WEST SUSSEX COUNTY COUNCIL CONSULTATION

TO:	Arun District Council FAO:David Easton
FROM:	WSSC Highways - Public Rights of Way
DATE:	11 July 2022
LOCATION:	Land South of Grevatts Lane/A259 Climping
SUBJECT:	M/16/22/PL Laying out of an 18 hole 72 par golf course, a 9 hole golf course, practice greens and a driving range including a buggy compound; the formation of a new access onto the A259; construction of a club house with associated golf club facilities; the construction of a maintenance building and external area of hardstanding; the laying of parking, new roads and paths; new landscape planting; surface water drainage basins and water storage reservoirs; and other earth works and infrastructure. This application also lies within the parishes of Climping and Yapton, is a Departure from the Development Plan and affects a Public Right of Way. This application is subject to an Environmental Statement. From Arun DC - I am able to inform you that I have received an amendment to the above application dated 21st June 2022 relating to:- amended plans to address consultee points and slight amendment to red line plans.

DATE OF SITE VISIT:	n/a
RELEVANT PUBLIC RIGHTS OF WAY NUMBER(S):	FP16

client Hallam Land Management		
project Bognor Regis Re-located Golf Course		
drawing title Softworks General Arrangement Sheet 2		
drawing status PLANNING		
drawn by LM	checked by SF	date 07 Feb 22
scale 1:500	paper size A0	
job/dwg no. 171-UW-P-B-025 (2)	rev. B

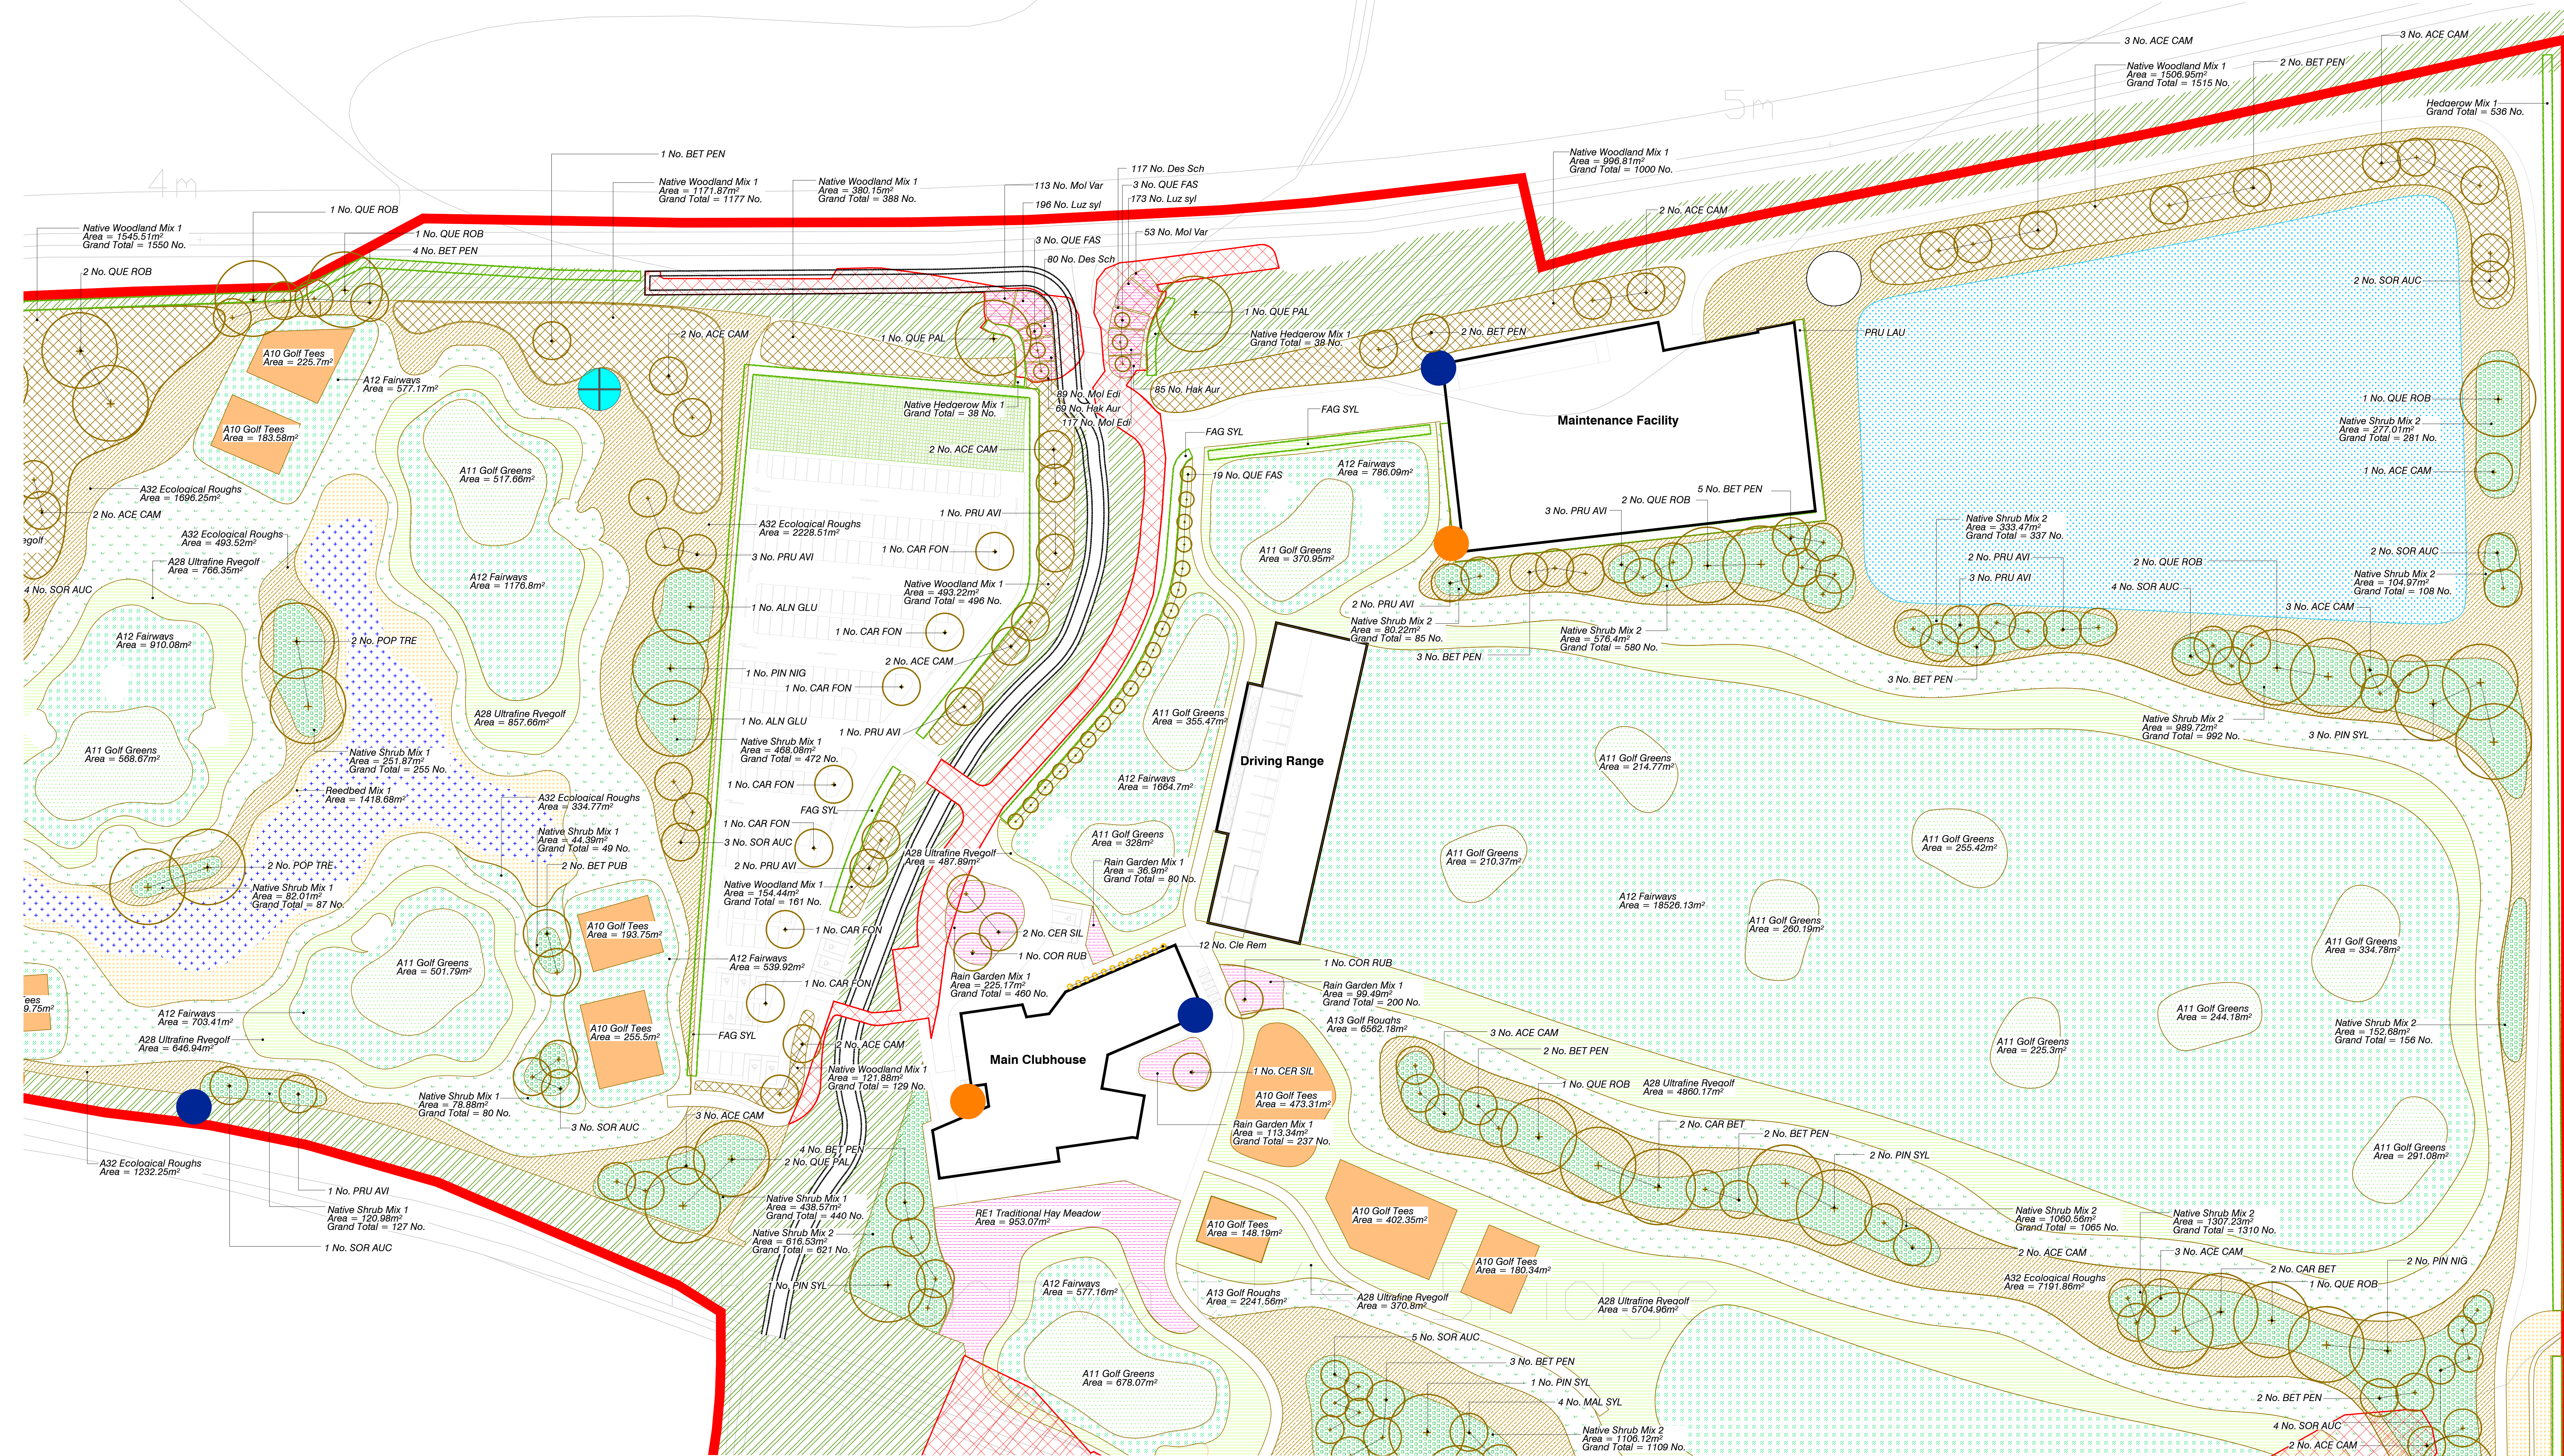
I also welcome your intention to improve the remainder of the route south including the surface. This intention is contradicted however with *The Rights of Way Details 171-UW-P-B-026 Rev B* document which indicates that the route is merely to be retained, not improved.

Whilst I understand there is a need for different treatment of the remainder of the route south, I would welcome the improvement of the surface of this section of the footpath, southwards, through the new golf course. Specifically, I would look for the surface to meet our specifications for rural footpaths so that we can maintain the route going forward. Any TPOs with Root Protection Areas may require different treatment which can be advised on by the WSCC PRoW team.
